**RE: SSD-17424905**

**Project: Pymble Ladies College – Grey House Precinct**

Morris Goding Access Consulting (MGAC) has been engaged to provide an accessibility review of the proposed Grey House Precinct Development located within the grounds of Pymble Ladies College (PLC) at Pymble.

**GENERAL ARRANGEMENT  
PLAN - LEVEL 02**

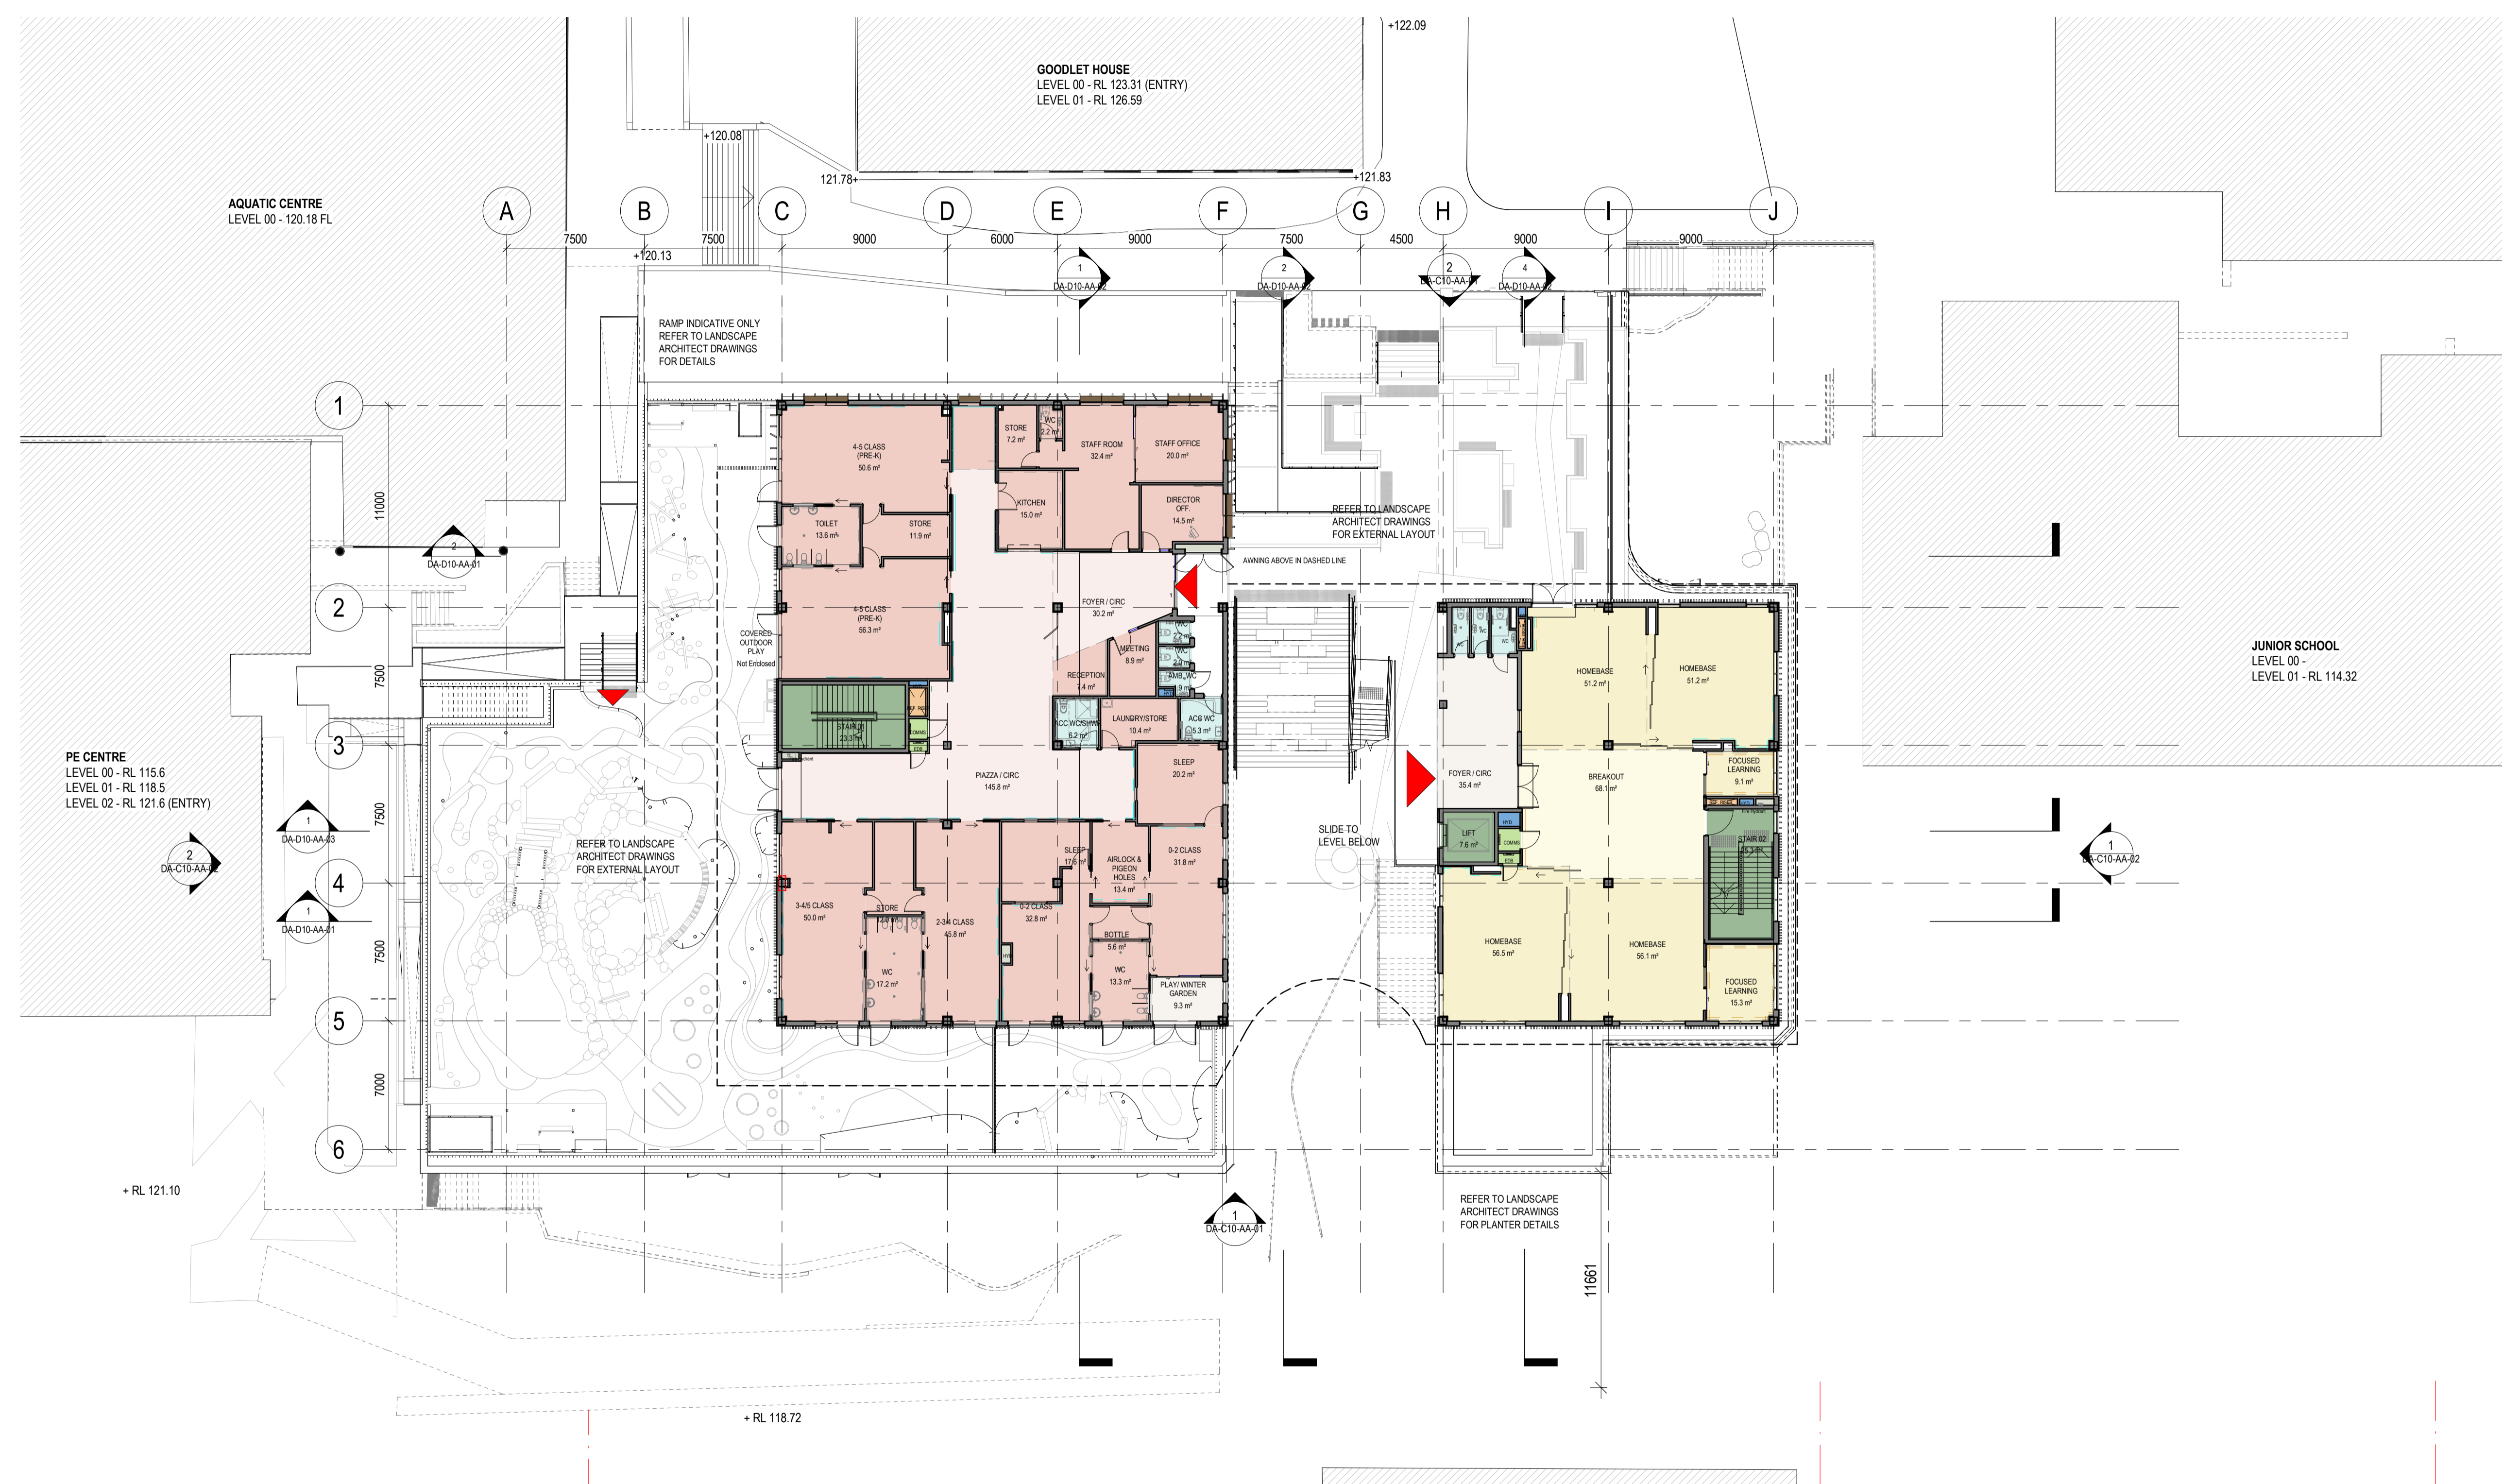
*SDRP have requested that details of accessibility at all levels of the building be provided, noting the massive change of levels within the site.*

Access has been provided through all levels of the building via a central passenger lift. This lift is accessed through the entry level on Level 1. The central passenger lift facilitates access throughout the Grey House Precinct building from Level 1 down to Level 0; and through to the external outdoor play area immediately adjacent to the proposed building. The central lift also continues through to all other levels above from the entry Level 1 through to Levels 2 to 4. Refer to attached makeups by MGAC.
